**Addendum No. 1**

RE: Contract # C204204

**Wake County (P-5720)**

GRADE SEPARATION OF SR-2006 (DURANT ROAD) OVER CSX S LINE  
RAILROAD IN RALEIGH

DRAWN BY: J. I. KIMBLE DATE: 1/19  
 CHECKED BY: M. D. MAGEE DATE: 1/19  
 DESIGN ENGINEER OF RECORD: S. A. DENNEY DATE: 1/19

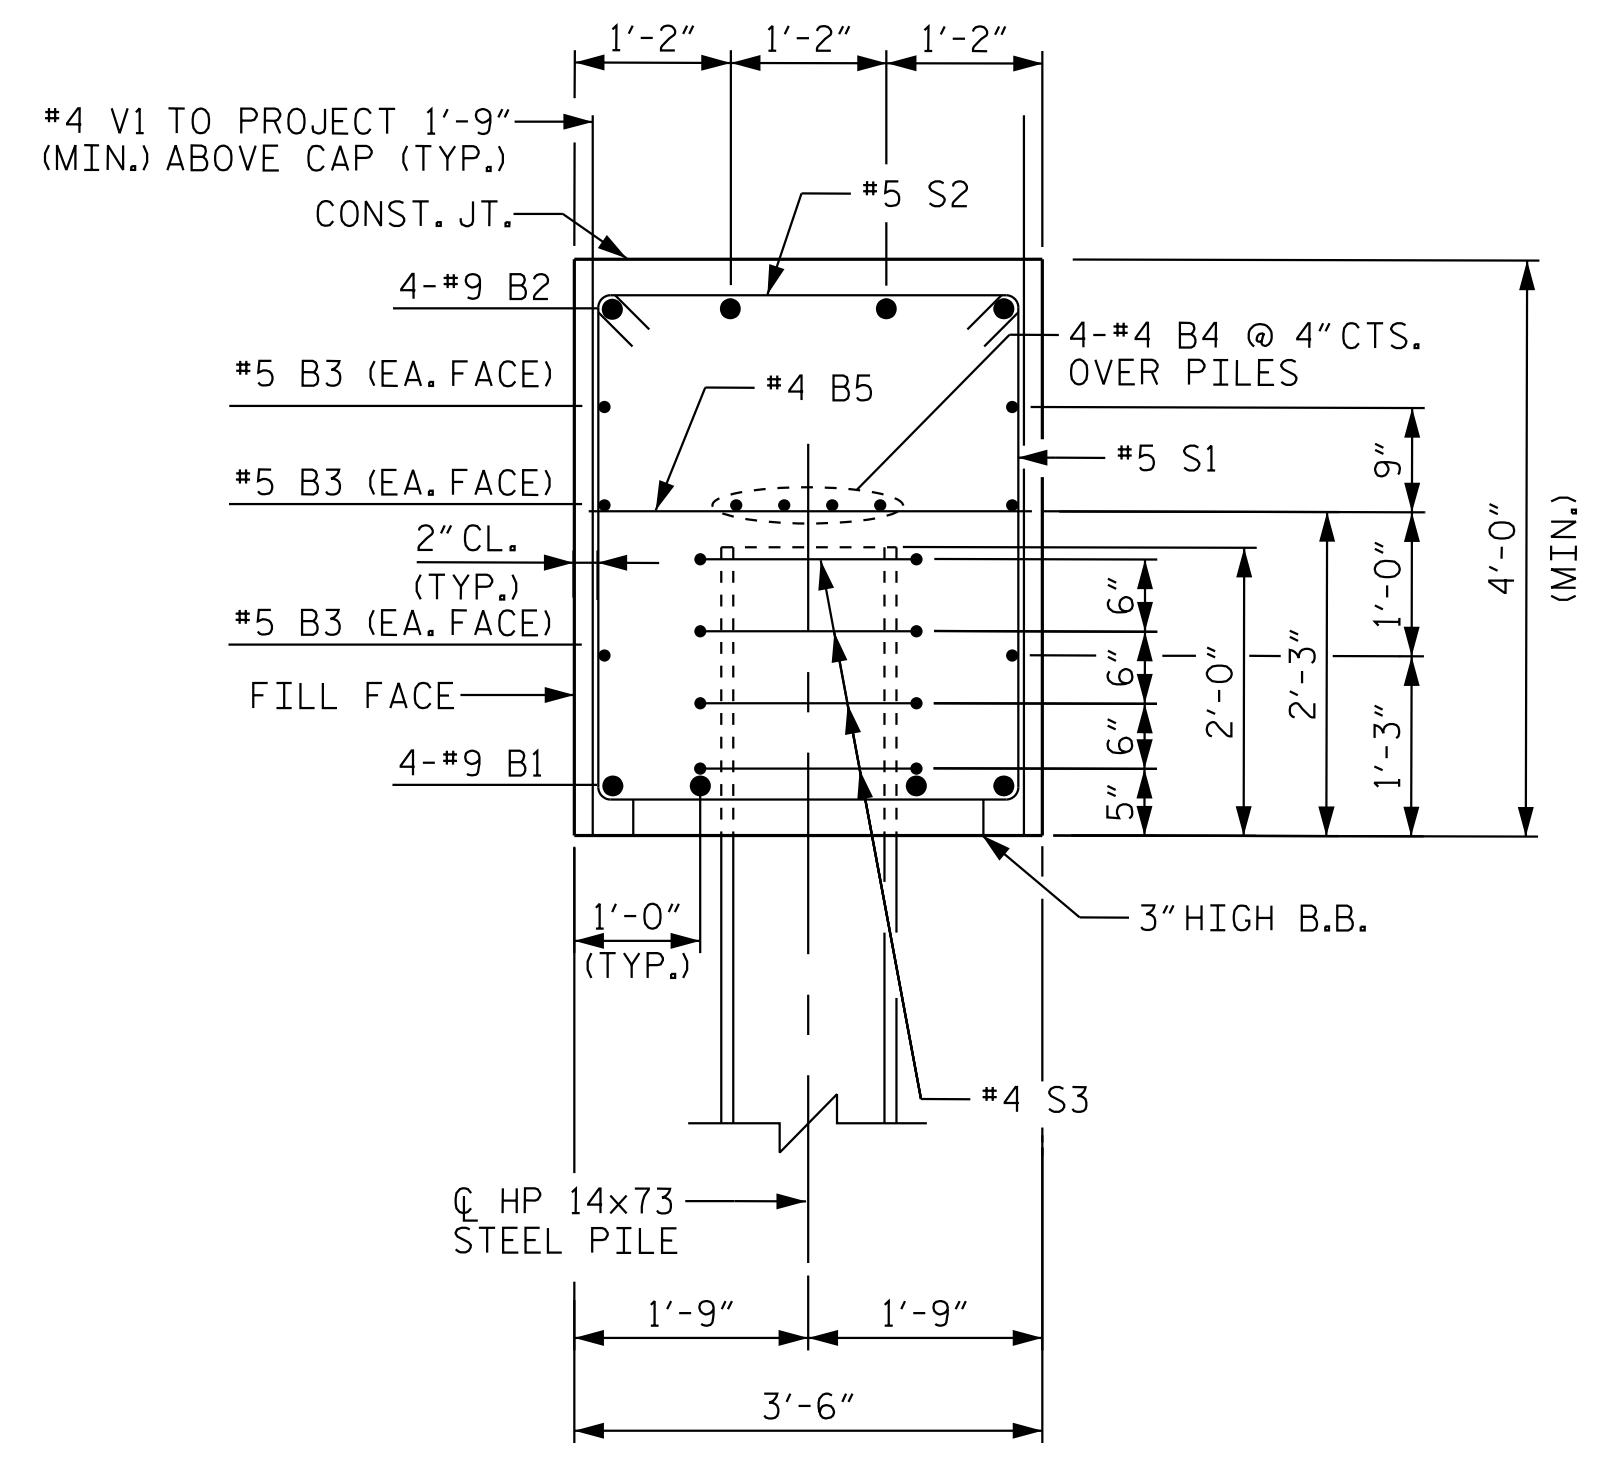
S-27	Updated V1 bar configuration for 54" FIB and beam seat elevations.
S-28	Wing steel corrected.
S-29	Updated quantity of V1 for 54" FIBs.
S-30	Updated berm elevations.
S-31	Approach Fill type revised.
S-32	Overhang depth corrected.
